Development Facilitation Team (DFT) – Review Comments

DRB Project No: PR-2023-008090 Date: 03/22/2023 Agenda Item: NA Zone Atlas Page: J-17

Application For: SD-2023-00057 – PRELIMINARY/FINAL PLAT (DHO)

DRB Project Number: 2023-008090
4915 Lomas

PLAT OF LOT 1-A WH RICHARDSON'S SUBDIVISION OF TRACT 4, PUEBLO ALTO WITHIN SECTION 14, T. 10 N., R. 3 E., N.M.P.M. CITY OF ALBUQUERQUE BERNALILLO COUNTY, NEW MEXICO FEBRUARY 2023

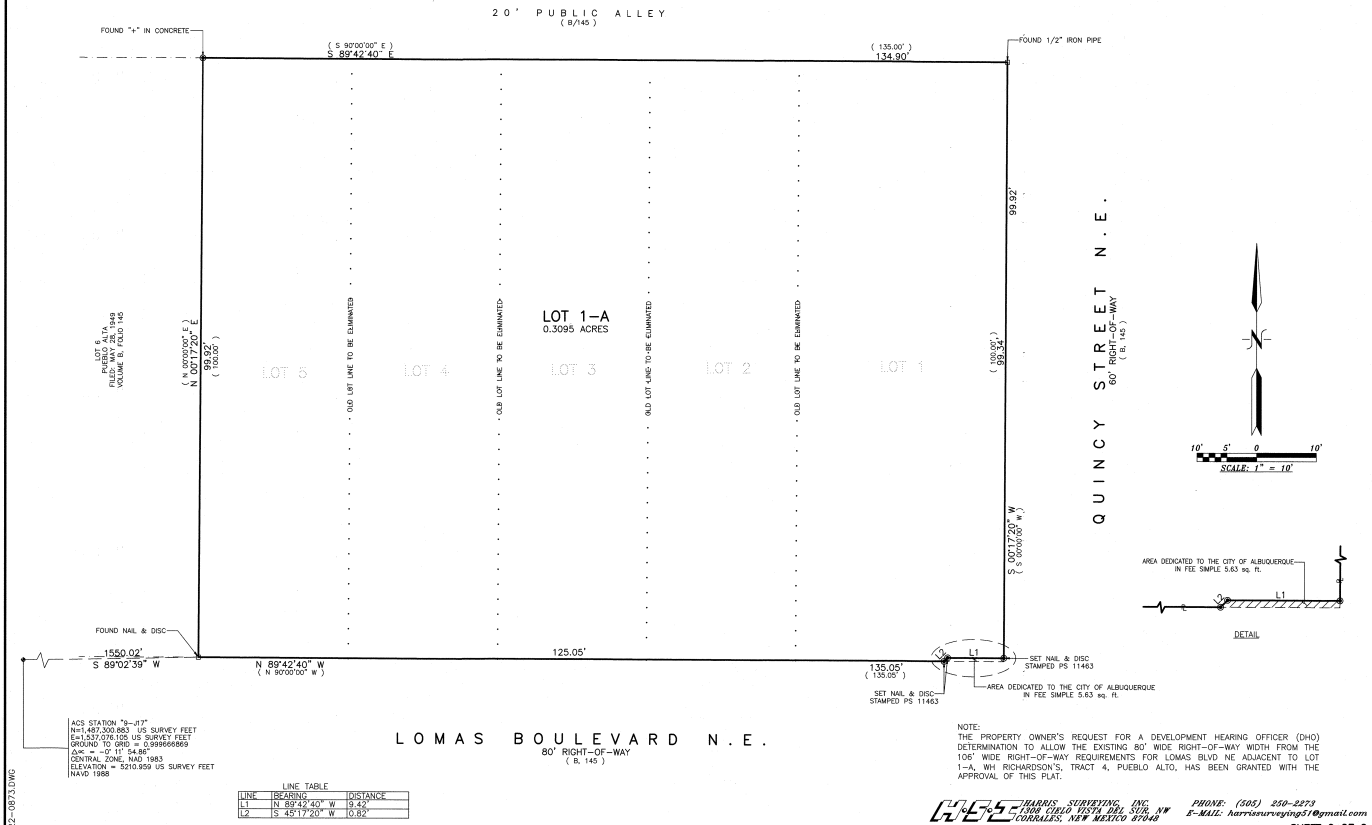
2. Lomas, as a Principal Arterial, also requires a minimum ROW width of 106' based on the DPM table 7.3.34. Any deviations from this would require a DHO Determination based on a justification letter that would need to be provided. I did not see a justification letter attached.

3. The curb cut on Quincy nearest to Lomas is too close to the intersection. In its current configuration the ADA ramp makes a sharp transition from corner curb ramp transition to driveway transition. A minimum 5' flat portion of sidewalk needs to be between the corner ramp transition and the driveway transition to meet ADA standards. Calling this out on the infrastructure list is not needed and just needs to be show on a plan.

- Please clarify compliance of section 7 of the DPM, Table 7.2.29, regarding sidewalk width and landscape buffer.
Lomas is a Major Transit Corridor requiring 6-10 foot sidewalk and 6-8 foot landscape buffer. Infrastructure list includes a 6 foot sidewalk. **Justify why a 5 foot landscape buffer is being provided.**
Quincy Road is a local road requiring a 5-foot sidewalk and a 4-6 foot landscape buffer. A landscape buffer currently exists, but there are no plants in the buffer. The infrastructure list shows a new 5-foot sidewalk. **Please detail how you are maintaining a minimum 4-foot landscape buffer.**
